COTTAM SOLAR - Deadline 1 – 17 October 2023

Part 2 - APPENDIX 2 – Hedgerows/Views - Photographs/Photography raised at Open Floor Hearing Oral submission – Tuesday 5th September 2023.

ENVIRONMENTAL STATEMENT APPENDIX 8.1.5: PHOTOGRAPHY AND PHOTOMONTAGE METHODOLOGY PART 1 OF 5 January 2023

Viewpoint 11 Single Frame 50mm image (Winter)

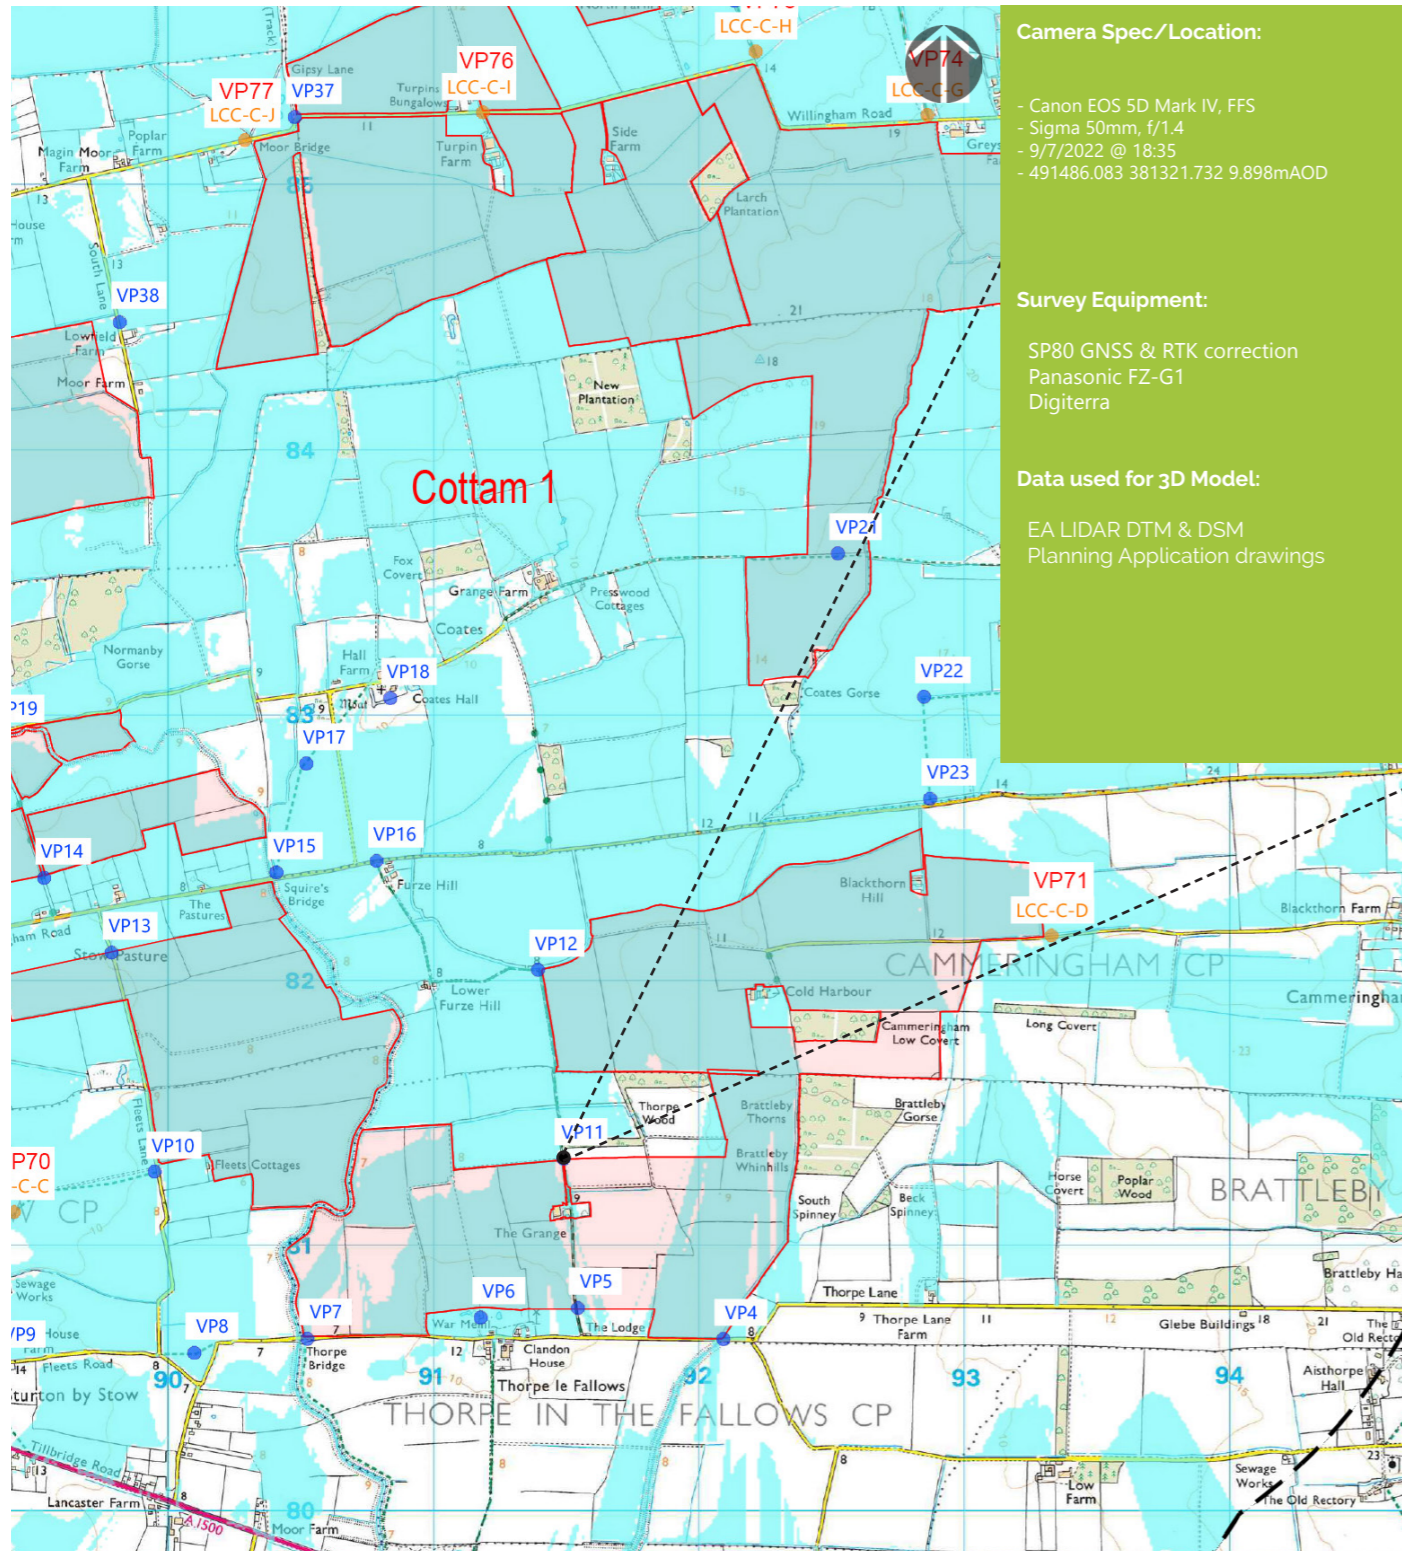
**Viewpoint 11** below has been taken from a private farm track alongside The Lodge on Thorpe Lane (Viewpoint 6). The camera angle is pointing directly at Thorpe Wood. None of the field(s) in front of this woodland will contain solar panels and this image really has little effect or no effect on mitigating the solar panels in the surrounding areas – the Woodland is tiny in scale in comparison to the Cottam Solar scheme. There are a monumental number of Viewpoints on this Solar scheme where the solar panels, sub-station, BESS batteries and other associated hardware will be clearly visible across this landscape. For example, Viewpoints 12 Lower Furze Hill,
